## Appeal Decision

**Appeal Ref: APP/R4408/D/20/3244307**

**7 Warner Place, Pogmoor, Barnsley S75 2EJ**

- The appeal is made under section 78 of the Town and Country Planning Act 1990 against a refusal to grant planning permission.
  - The appeal is made by Ms Alana Lunn against the decision of Barnsley Metropolitan Borough Council.
  - The application Ref 2019/1253, dated 7 October 2019, was refused by notice dated 6 December 2019.
  - The development proposed is a single storey rear extension with balcony.
-

Drawing Title **PROPOSED ELEVATIONS**

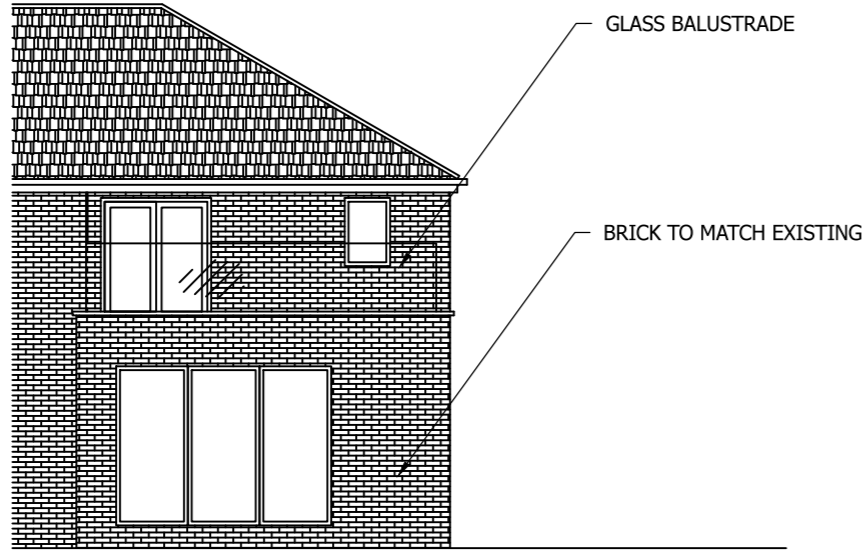
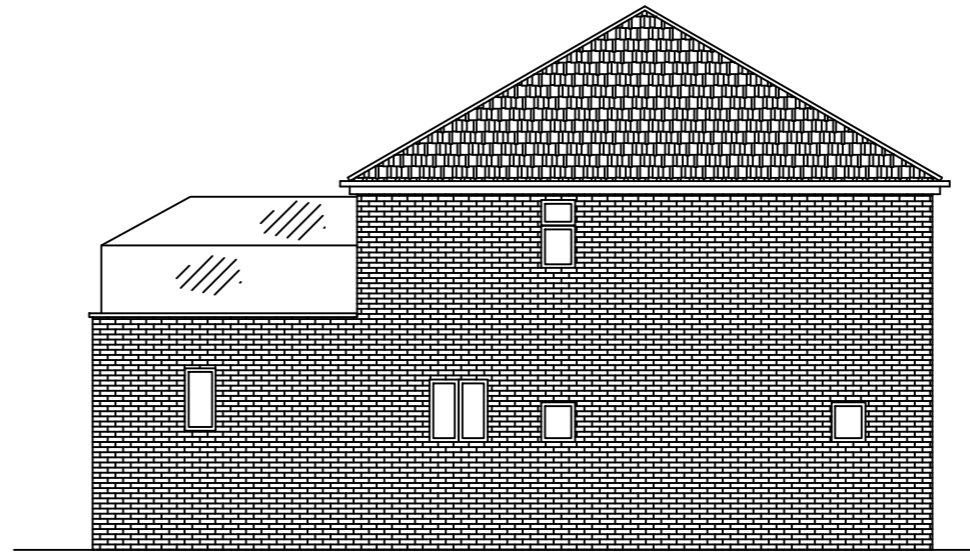
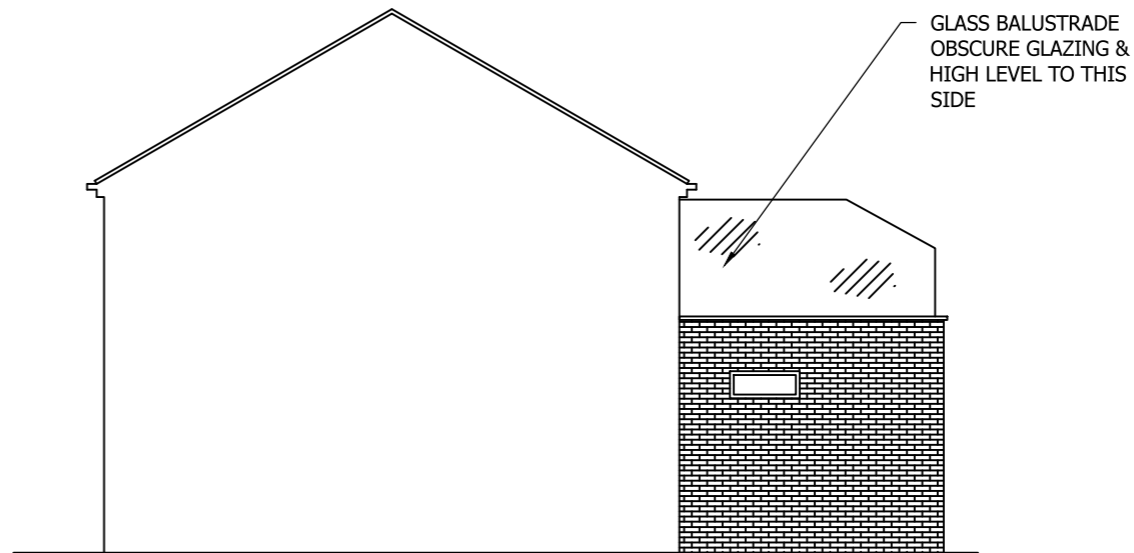
6. The proposed balcony would be positioned at the first-floor on top of the single storey rear extension. It would overlook, and be clearly visible from, the rear garden of the adjoining property, 8 Warner Place. Due to its siting and elevated position, the proposed balcony would result in a significant loss of privacy and an unacceptable level of overlooking of the garden of 8 Warner Place. Due to the rear gardens of other properties being further away from the appeal property, I find that the effect on those properties would not be unacceptable.

7. Although a privacy screen is proposed on the side elevation of the balcony, I consider that such a screen would only marginally alleviate the harm that I have identified, which would be predominantly in a forward direction.

12. Although not within the Council's reason for refusal, the officer report considers that the proposed glass balustrade and privacy screen would be out of character with the surrounding area and have a negative impact. I find that whilst these features are not prevalent in the surrounding area, due to their size and siting, they would not be dominant or prominent features in the street scene and would not cause harm to the character and appearance of the area.
13. As the element of the appeal which I have allowed has been undertaken, it is not necessary to impose conditions requiring that the development be undertaken within 3 years, it is carried out in accordance with the approved plans, or that matching materials are used. No other conditions are necessary.
